## MEMORANDUM

SUBJECT: SF-19-004 – Homestead Filing No. 2 Sterling Ranch

MAIL KIOSK GRADING DETAIL

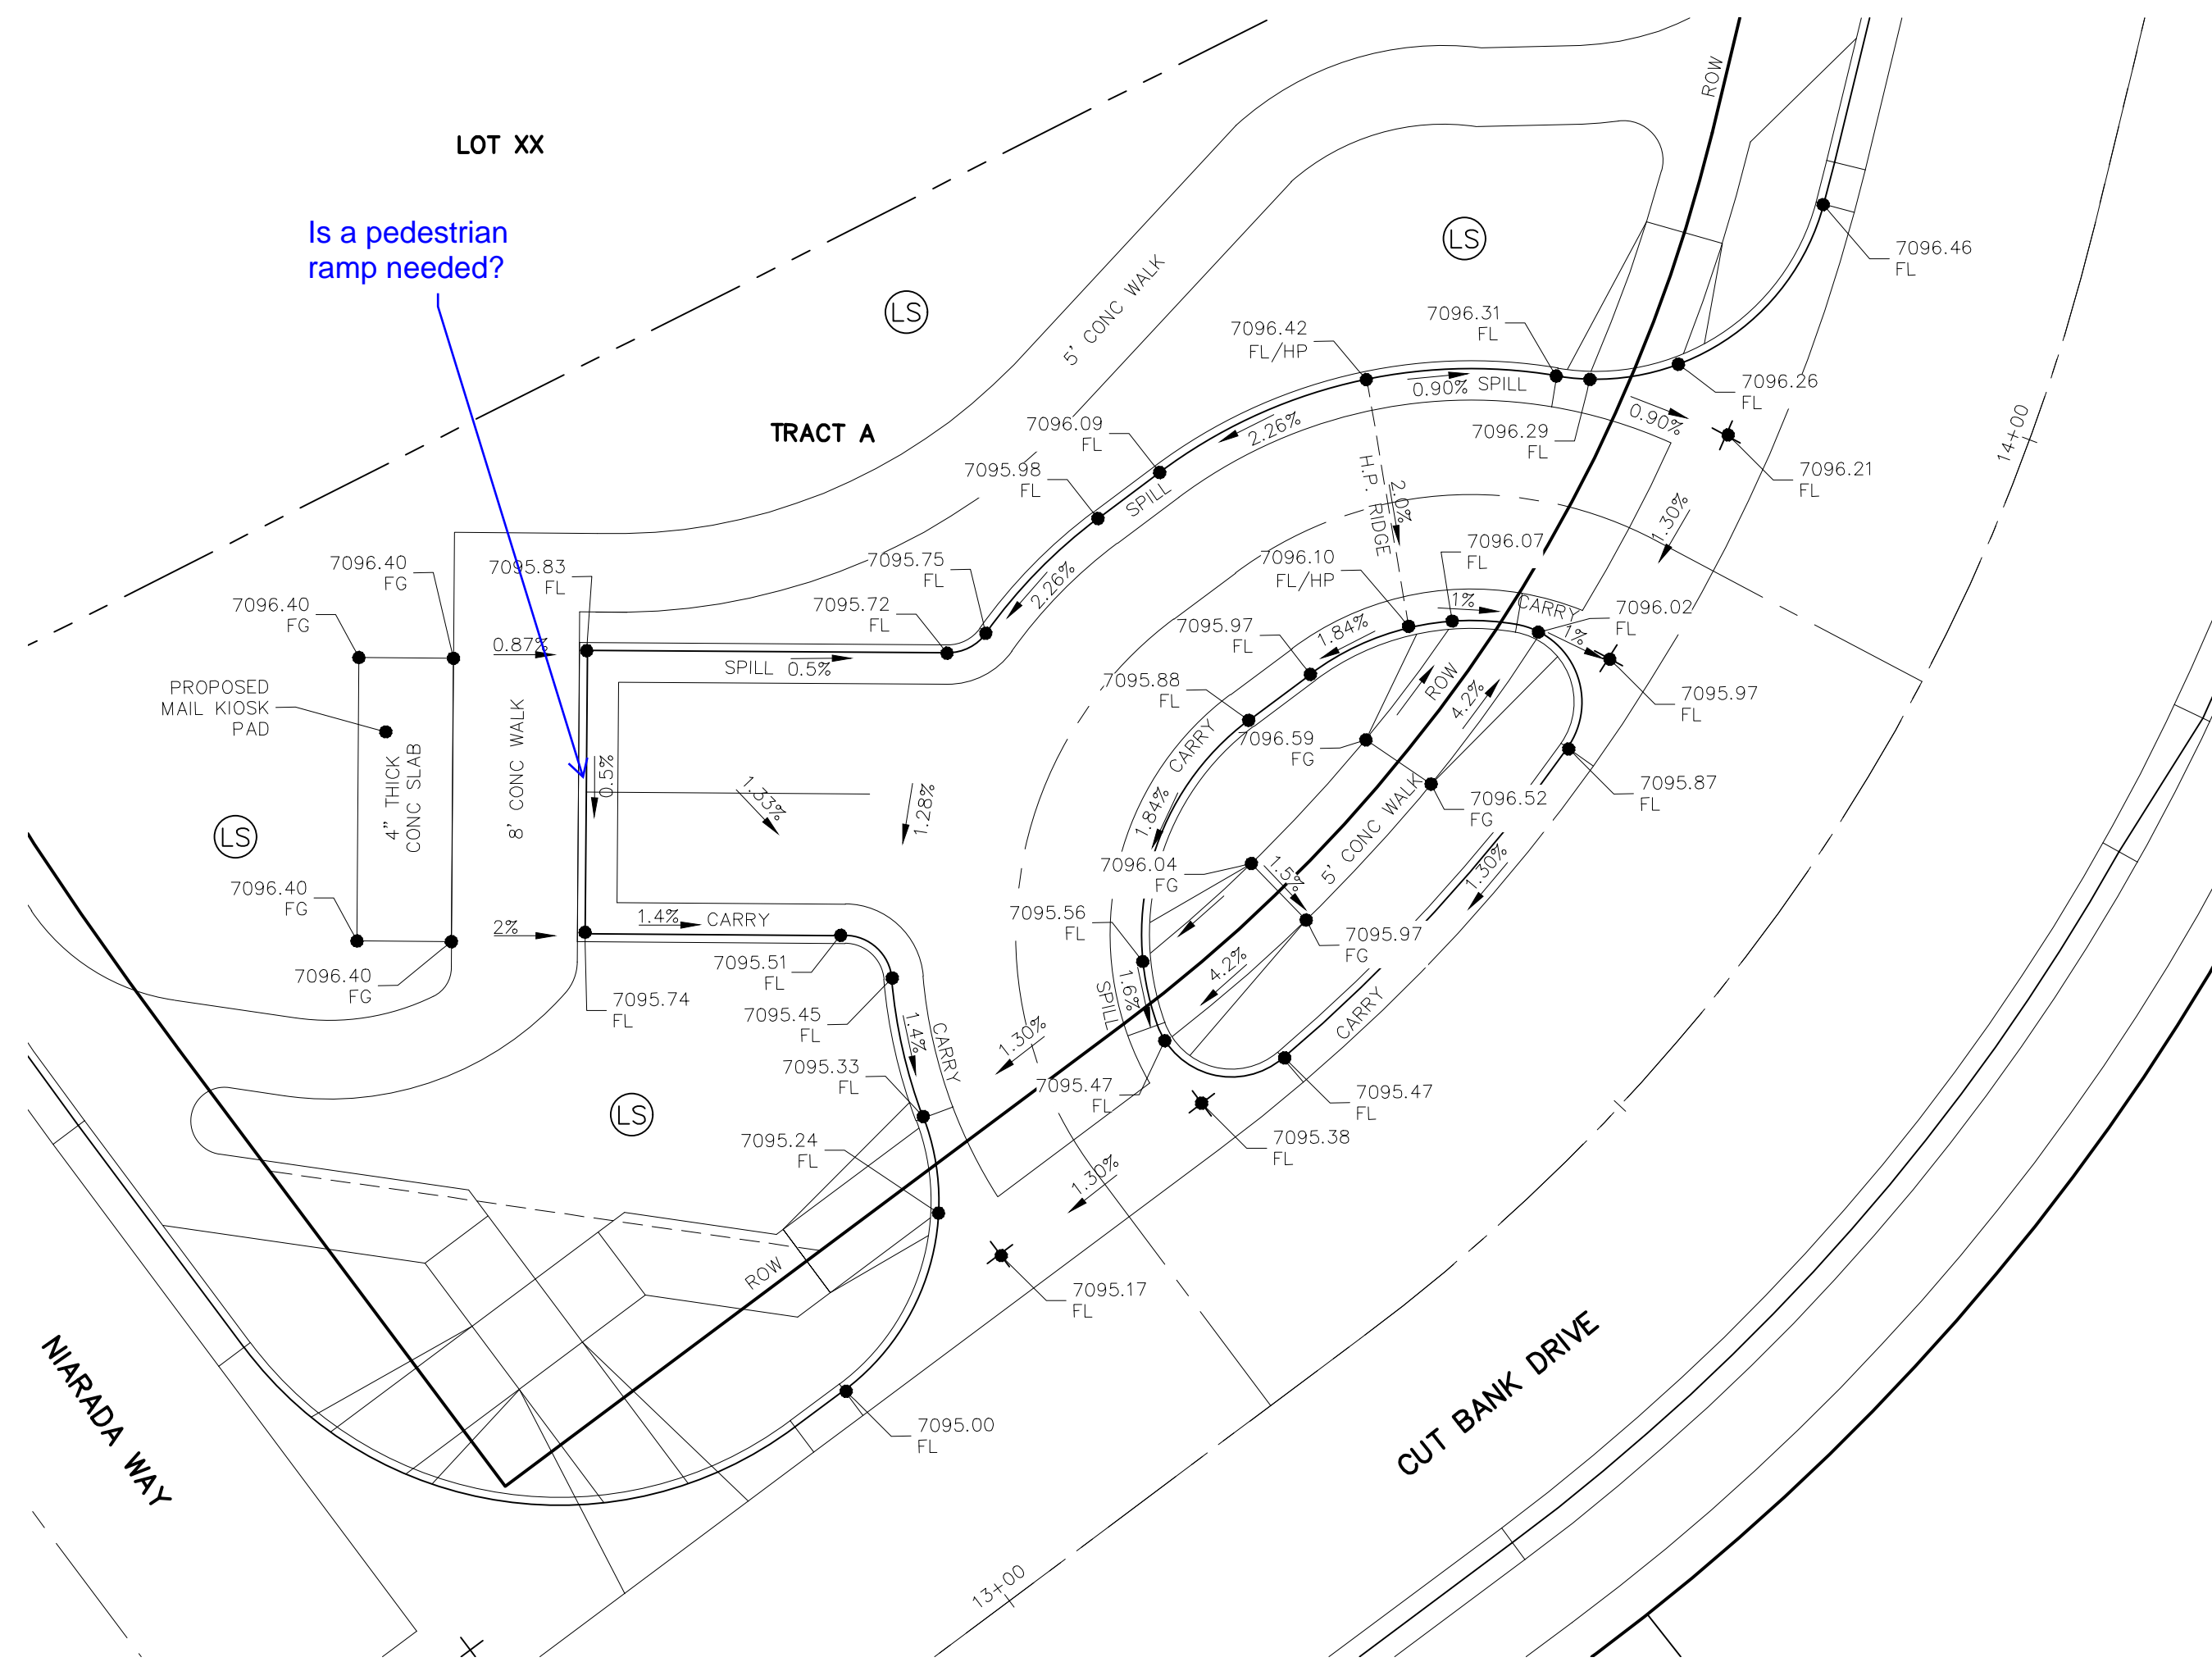
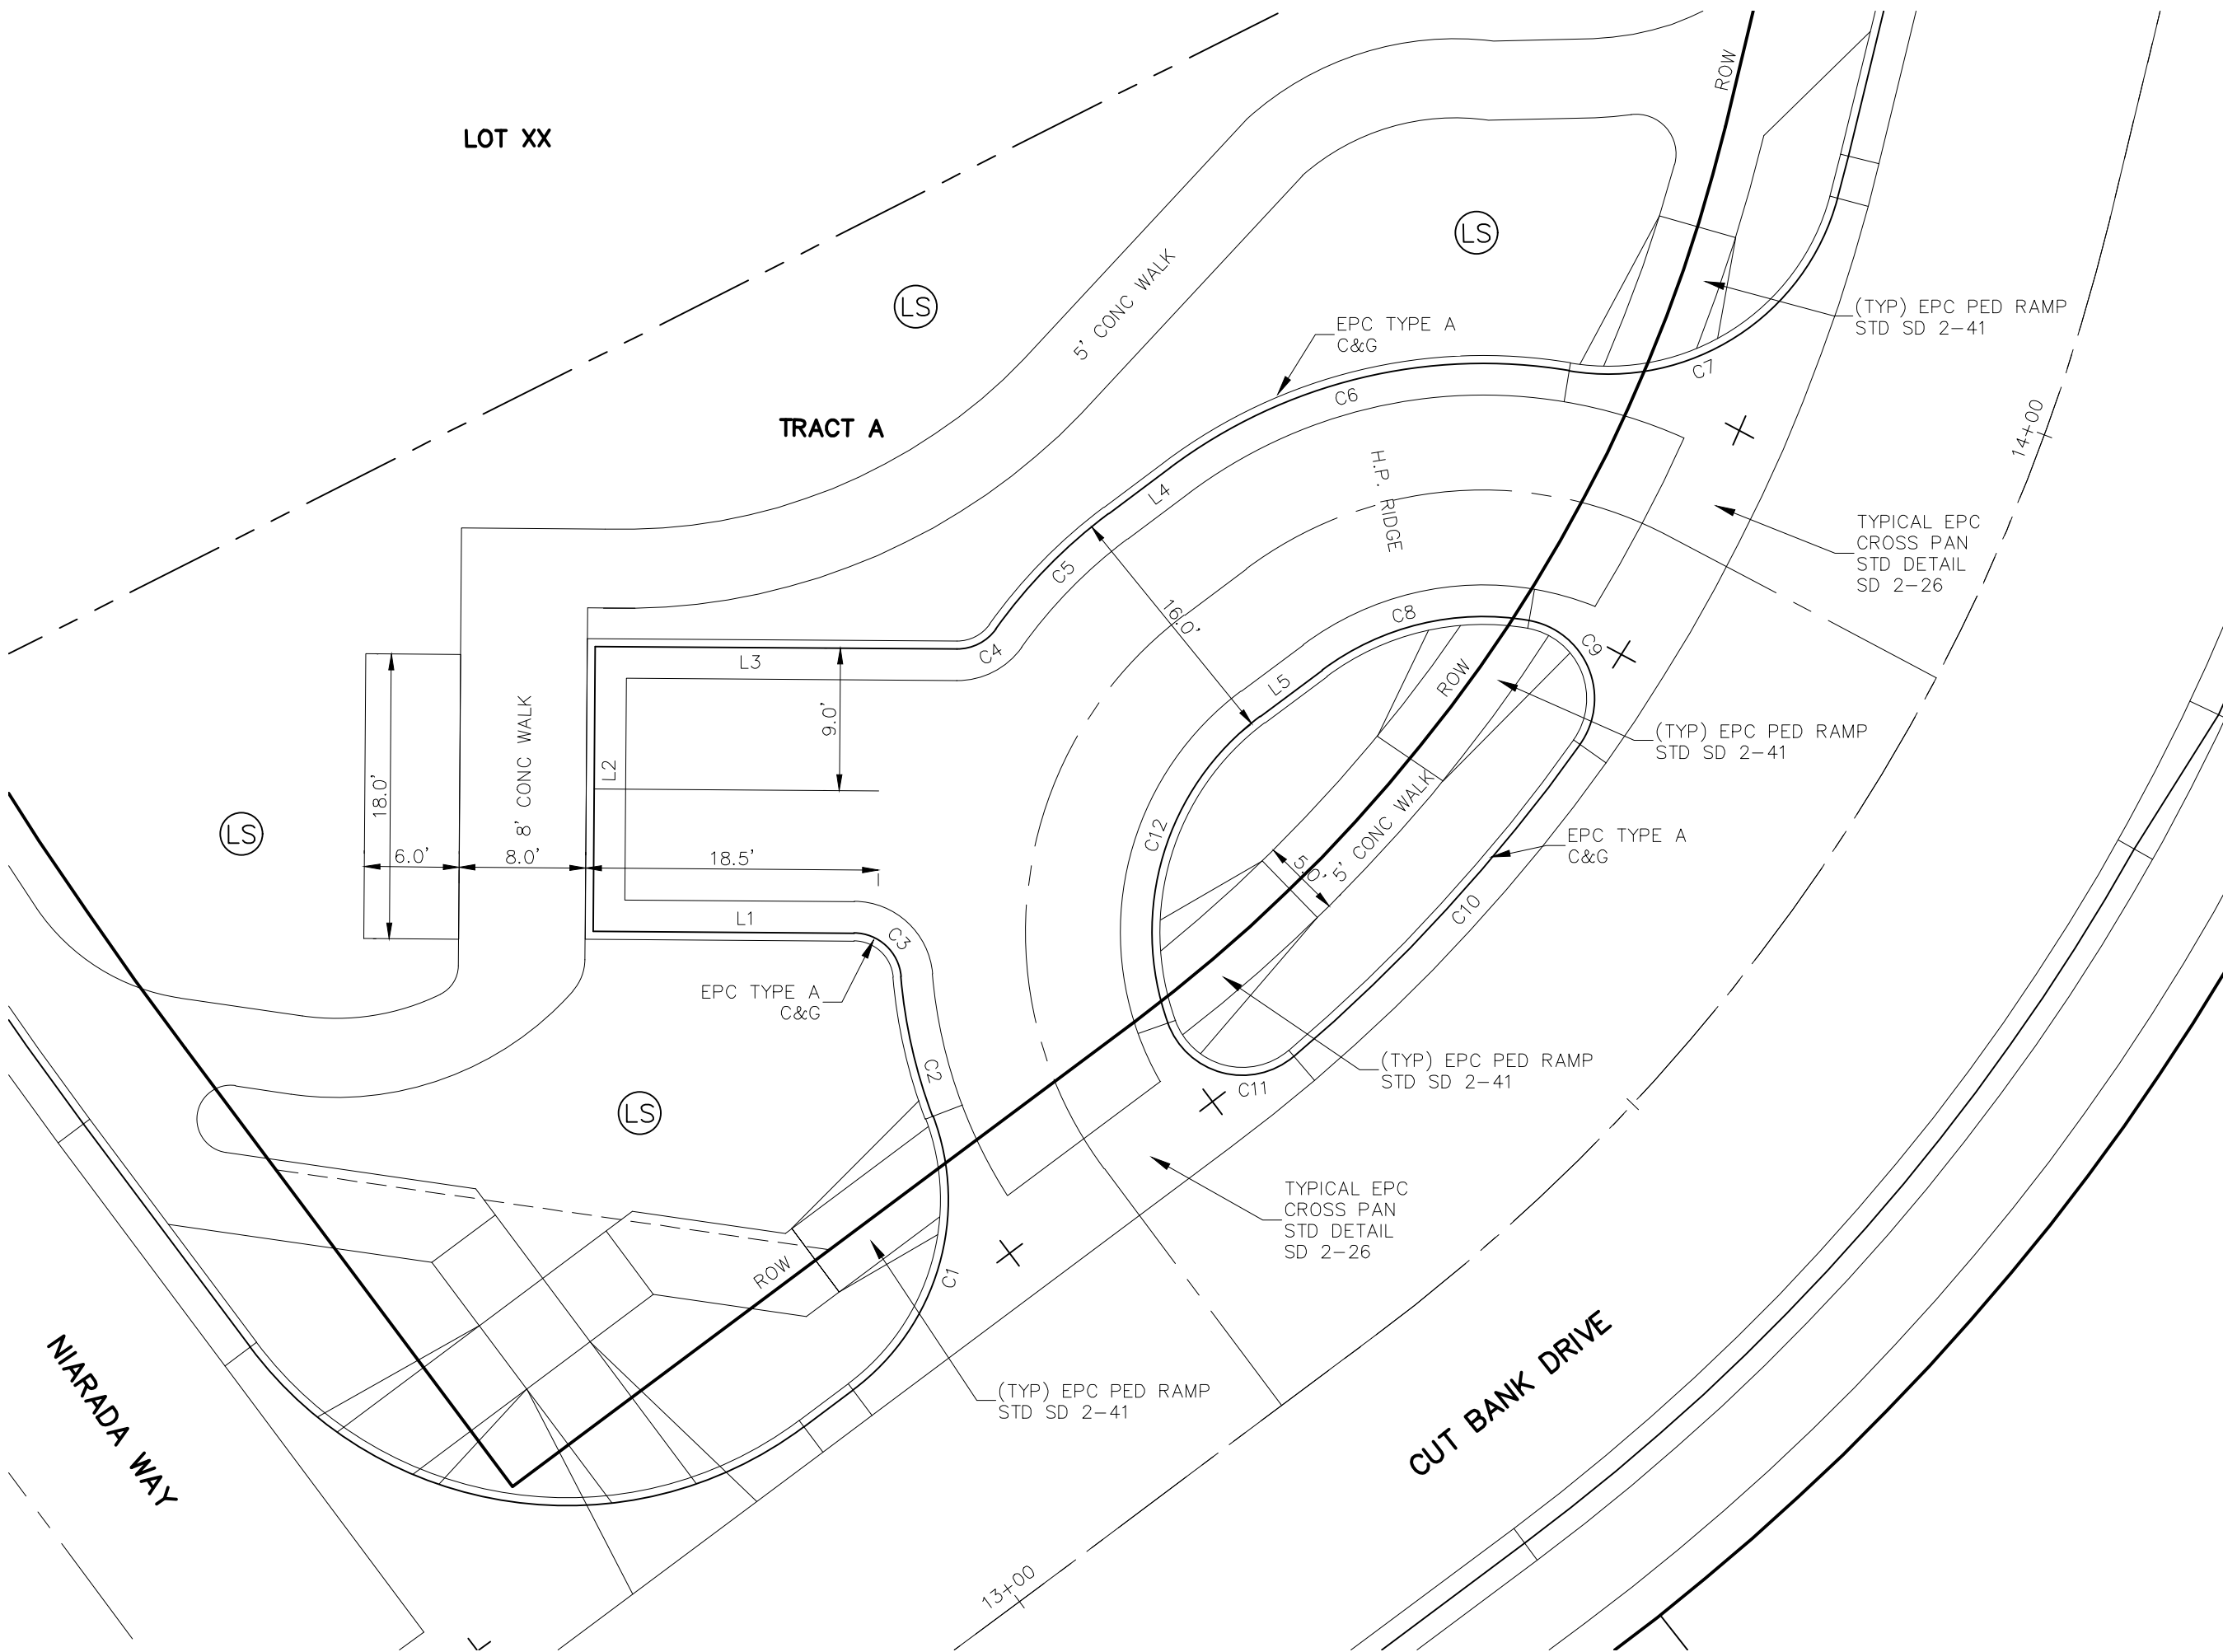
6. If there will be USPS mail kiosk/cluster(s) in this subdivision provide location(s) and details. *Partially resolved; provide detailed exhibit sheets (8-1/2" x 11") when available.*  
**Conditions to be provided.**
7. **Resolved.**

PROPOSED DRAINAGE MAP

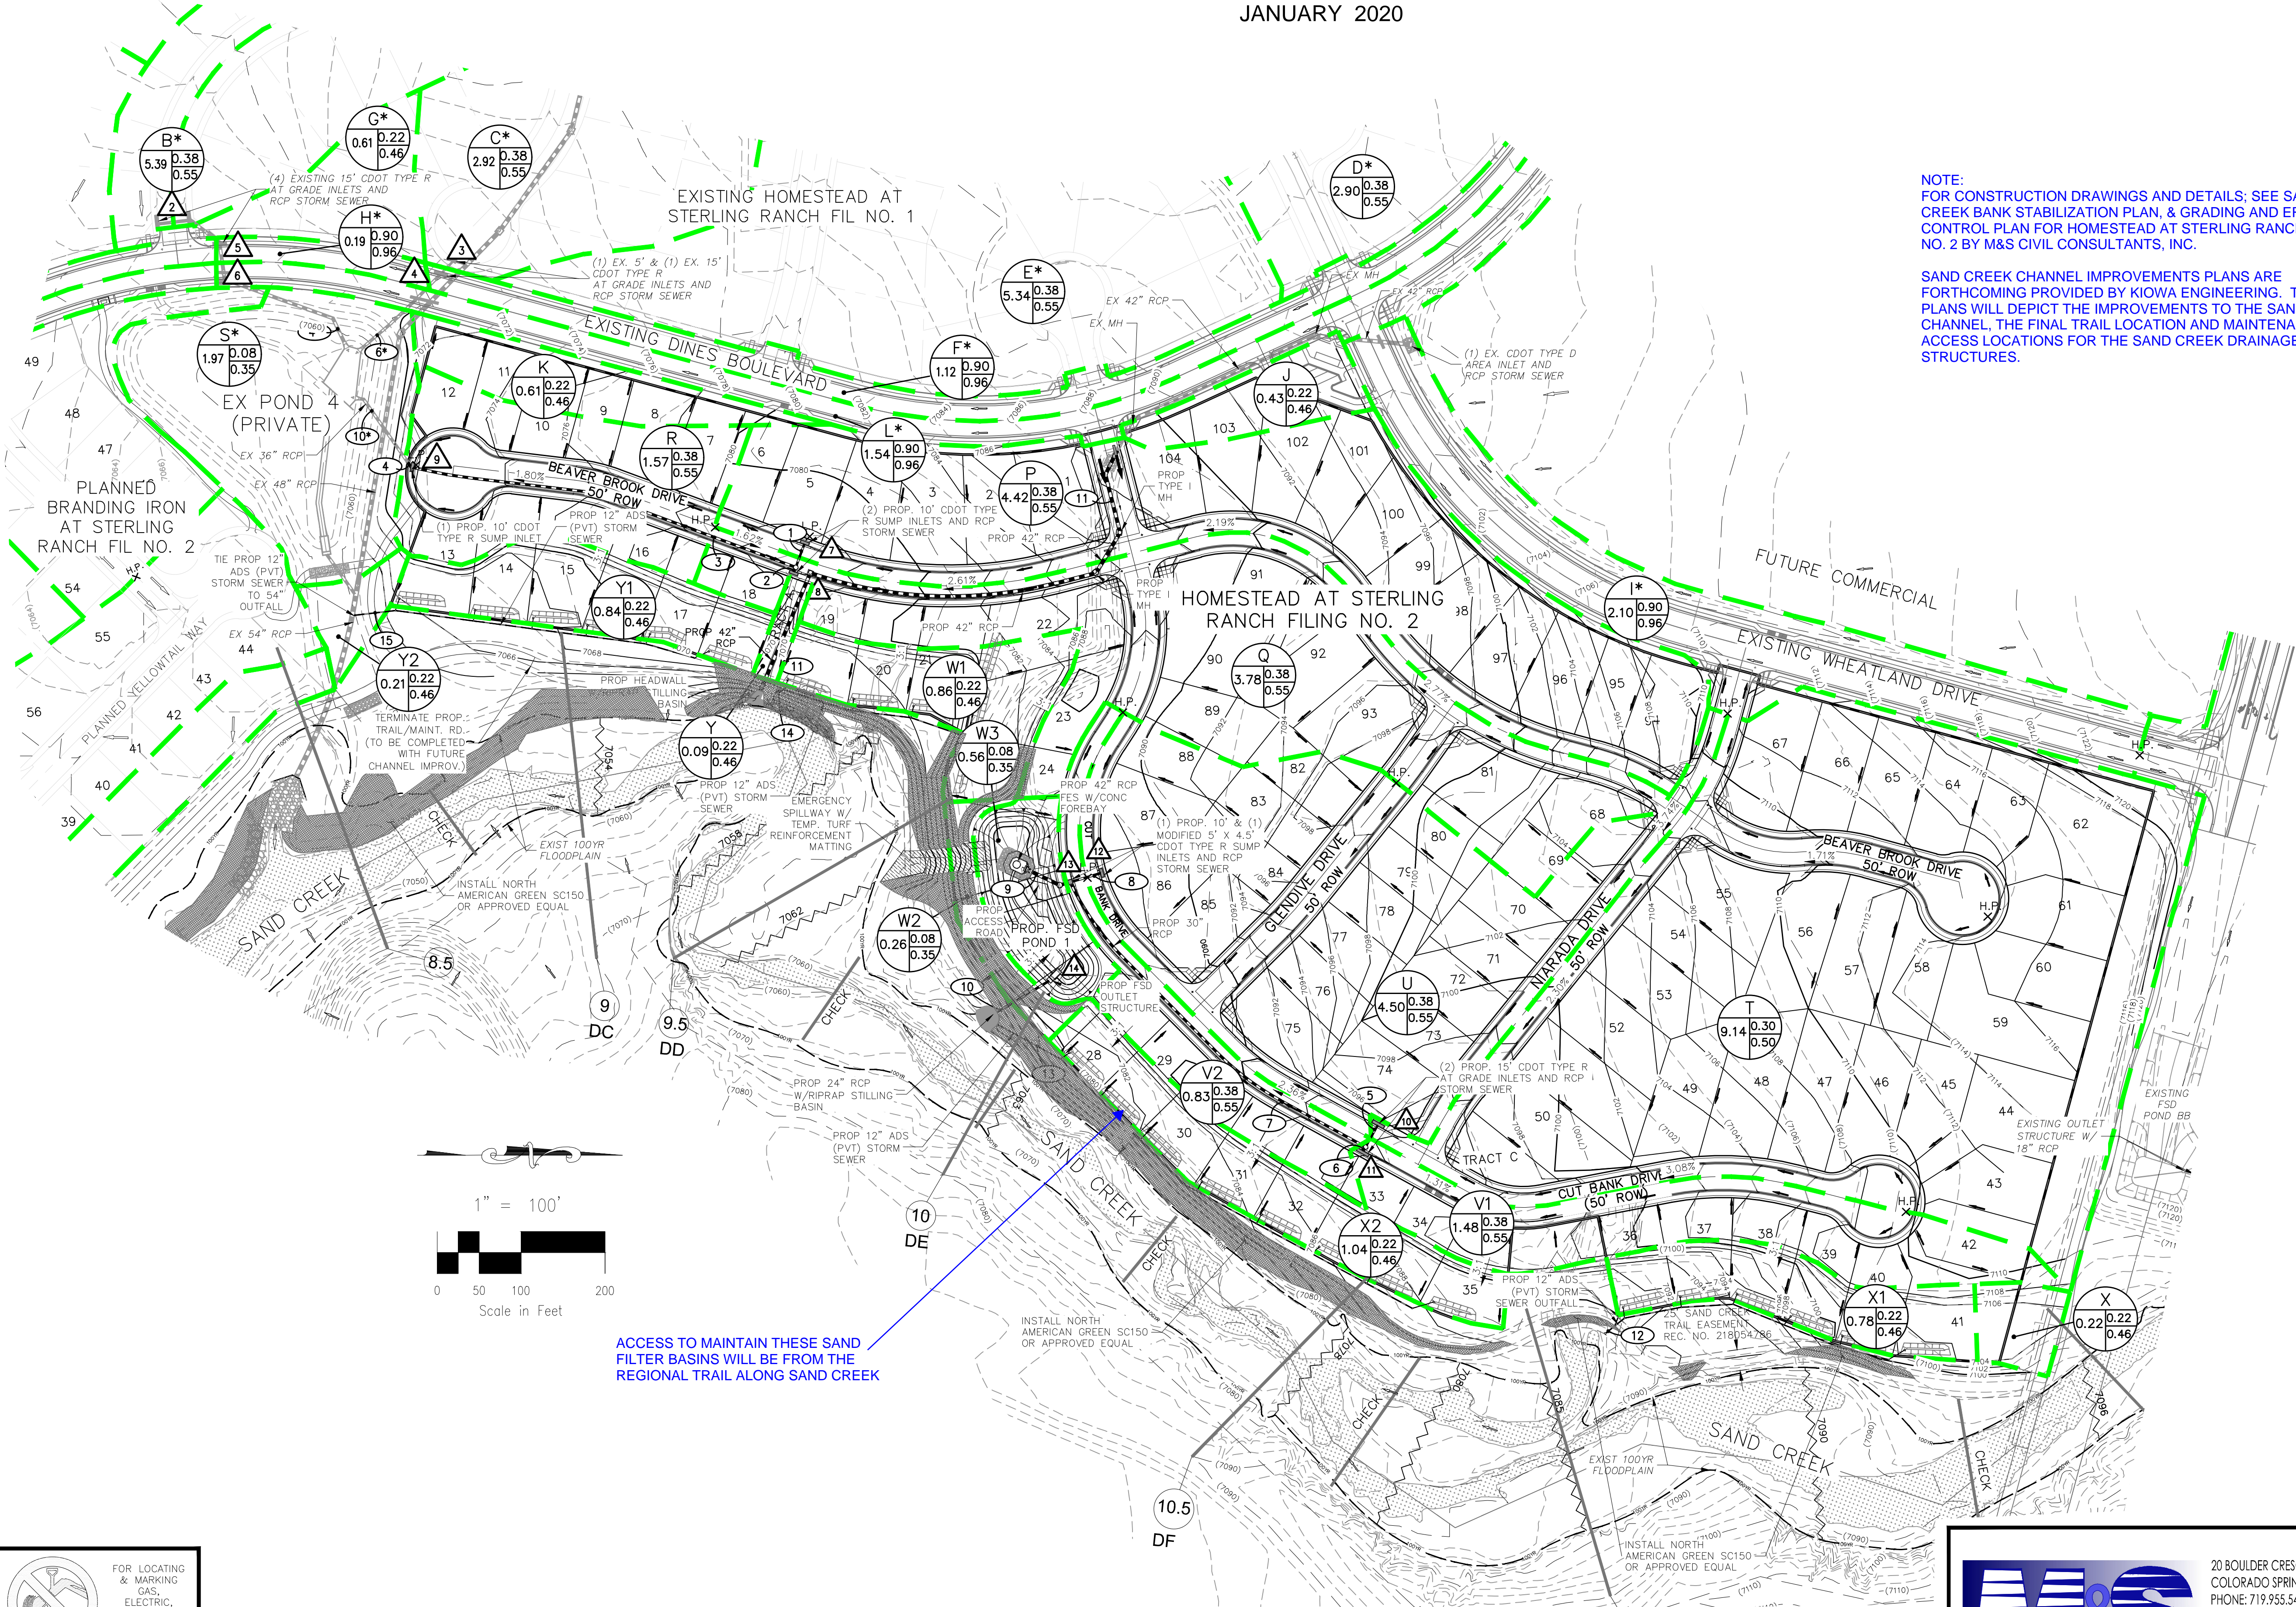
- b. Provide discussion of maintenance access and aspects of the preliminary design. Show access roads for ponds and channels on the drainage plans. Reference ECM 3.3.3.K. *Unresolved. Unresolved. See Final Plat comment #3.*

7. *Resolved.*
8. See updated FDR and drainage plan redlines. *Partially resolved;*
  - a. *Resolved.*
  - b. *The response that the trail will be utilized to access and maintain SFB’s requires the access road/trail to be constructed so that it can access the drainage facilities on the plans. Clearly show and label the complete access road/trail on the plans.*  
*Unresolved. See Final Plat comment #3.* **Conditions to be provided.**

- a. **Provide details, maintenance requirements and checklists for the SFBs.** Specifically address how access to the sand filter basins is to be obtained and provide a plan showing the access route. *Partially resolved; see plat note provided above; Provide details, maintenance requirements and checklists for the SFBs. The plat notes have been added. The details, maintenance requirements and checklists are provided in the O&M Report. We discussed this language in the prior review of the O&M. Is there more to add, other than what was received on 5/7/2020?*
